CAMPBELL'S RIDGE COMMUNITY - LOT 18

Stonefield Model — Elevation 7

2nd Floor Framing — Ledger At Rear Roof Trusses

M+K Project #: 126-24045 (40/01)

sheet:
S3.0

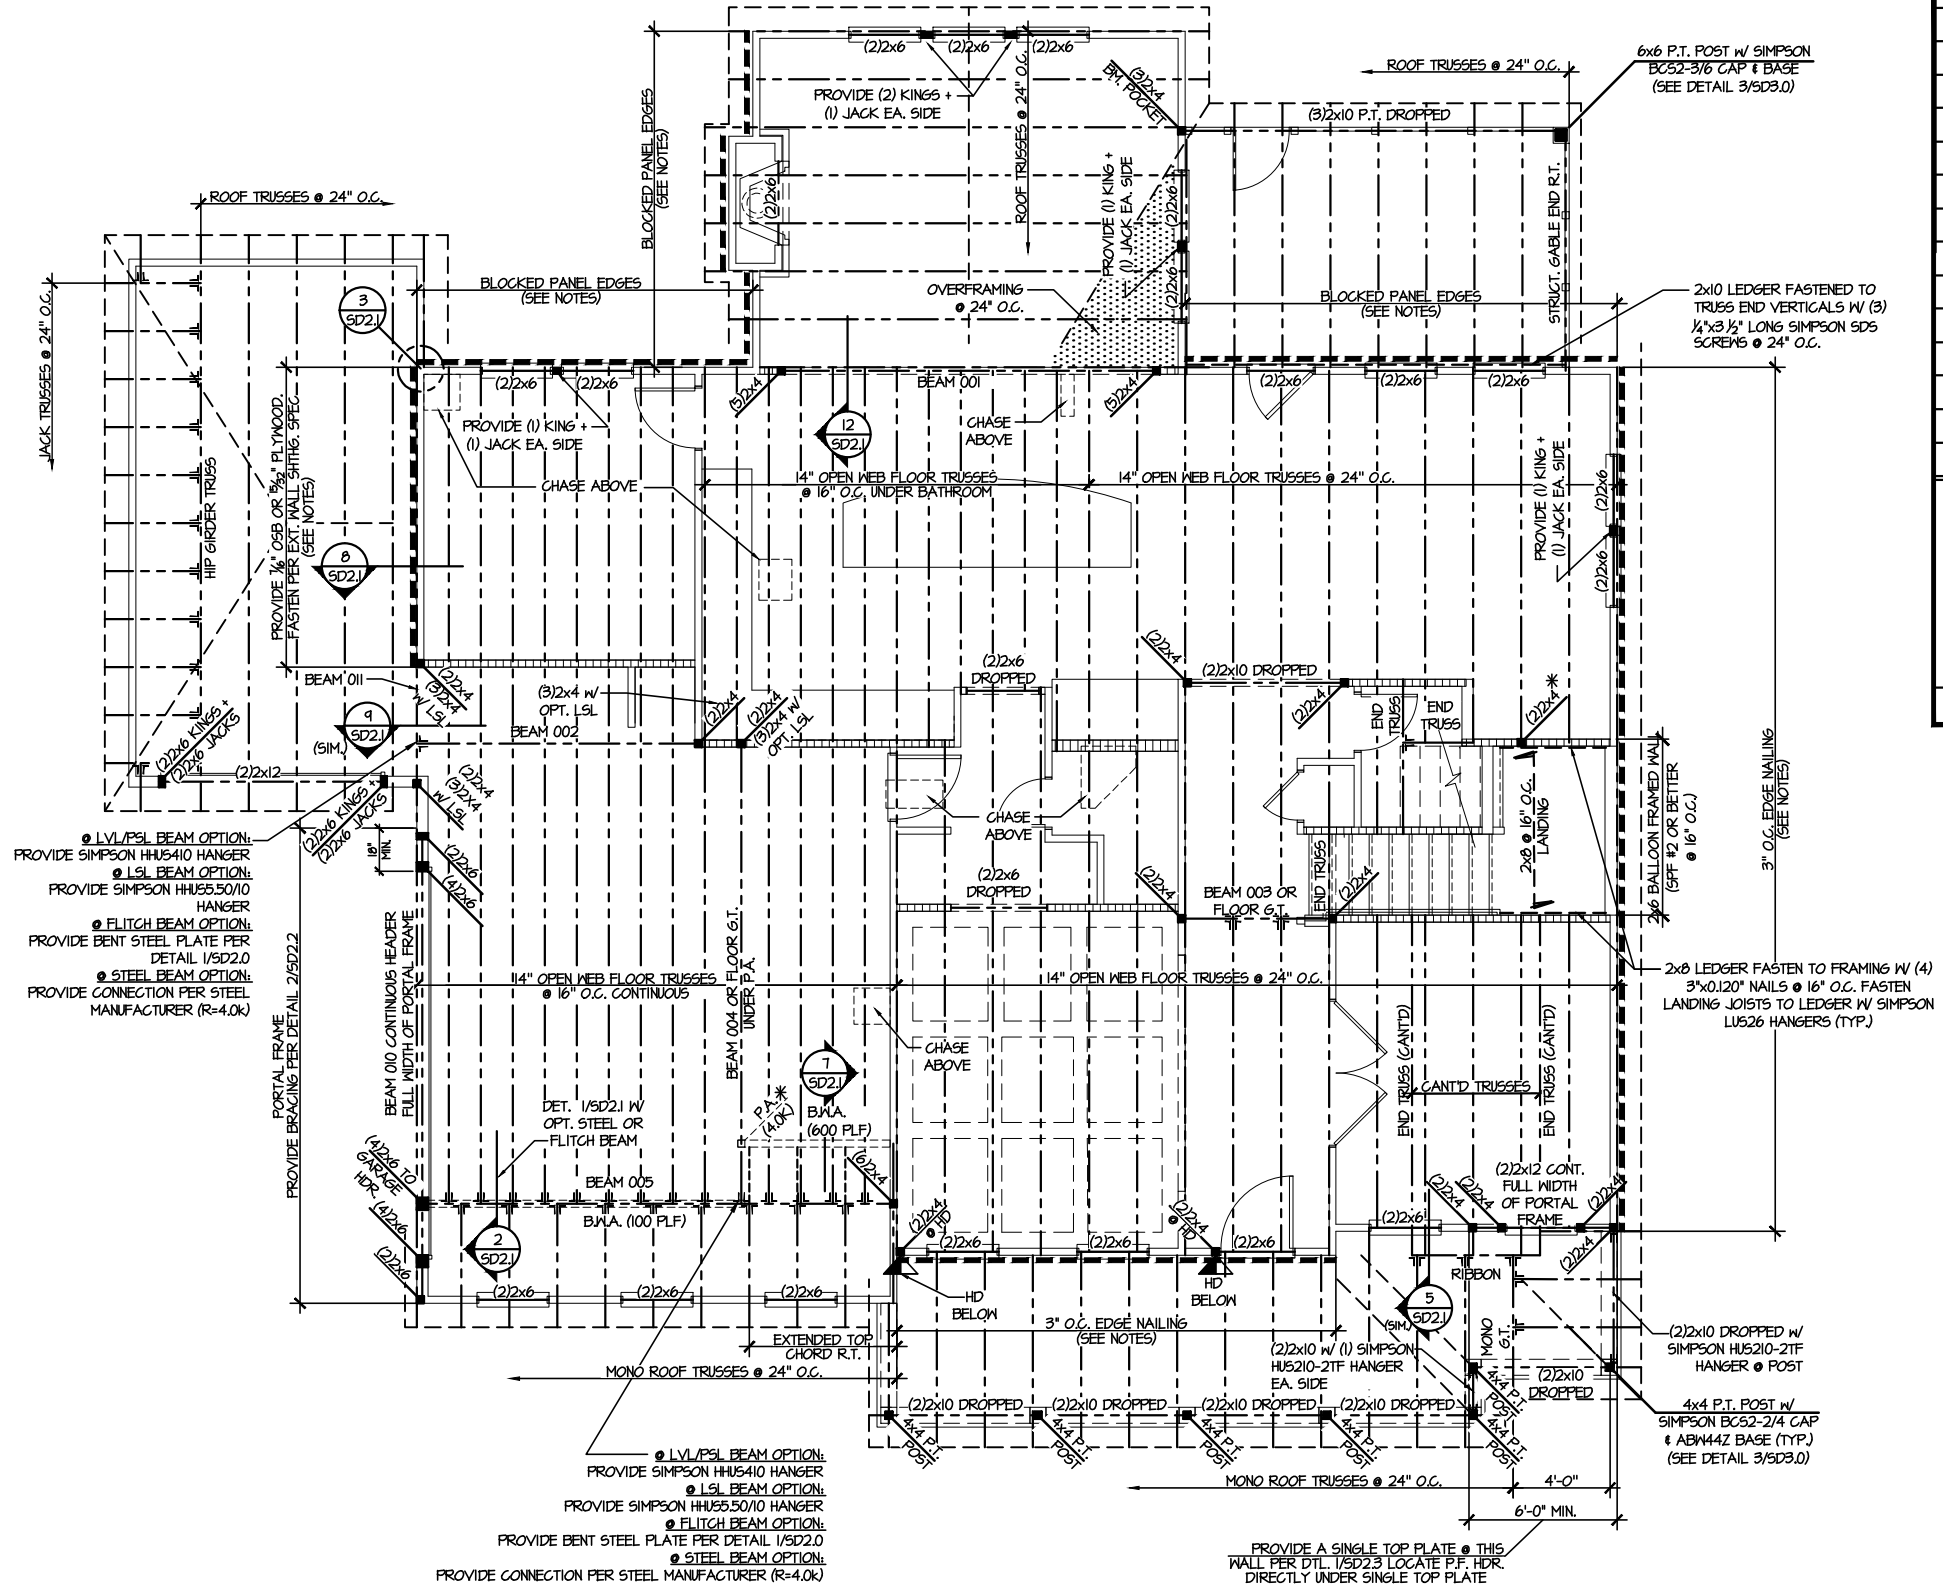
Pursuant to your request, we have prepared this letter to address the 2nd floor framing plan at the rear screened porch. It was reported to us, by you, that the 2x10 ledger was not installed to support the rear roof trusses, as shown on plan. Instead, the roof trusses have been hung to the OSB/plywood sheathing with hangers designed by the truss manufacturer. In addition, it was also reported to us, by you, that 2x10 blocking has been installed between each truss bay to provide a nailer for the roof truss hangers.

We have analyzed the existing framing and it is our professional opinion that the above referenced method of supporting the roof trusses is structurally adequate and no repairs are required as long as the following has been completed:

- 2x10 blocking is to be installed in each floor truss bay, and toenailed to the truss end vertical with (3) 0.120" diameter x 3" toenails at both ends, minimum.
- The 2x10 blocking is toenailed to the double top plate with 0.120" diameter x 3" long toenails @ 6" o.c, or fastened to the double top plate with (2) Simpson A35 clips in each bay.
- A 2x4 ribbon has been installed along the floor trusses as shown in detail C2/SD2.0.
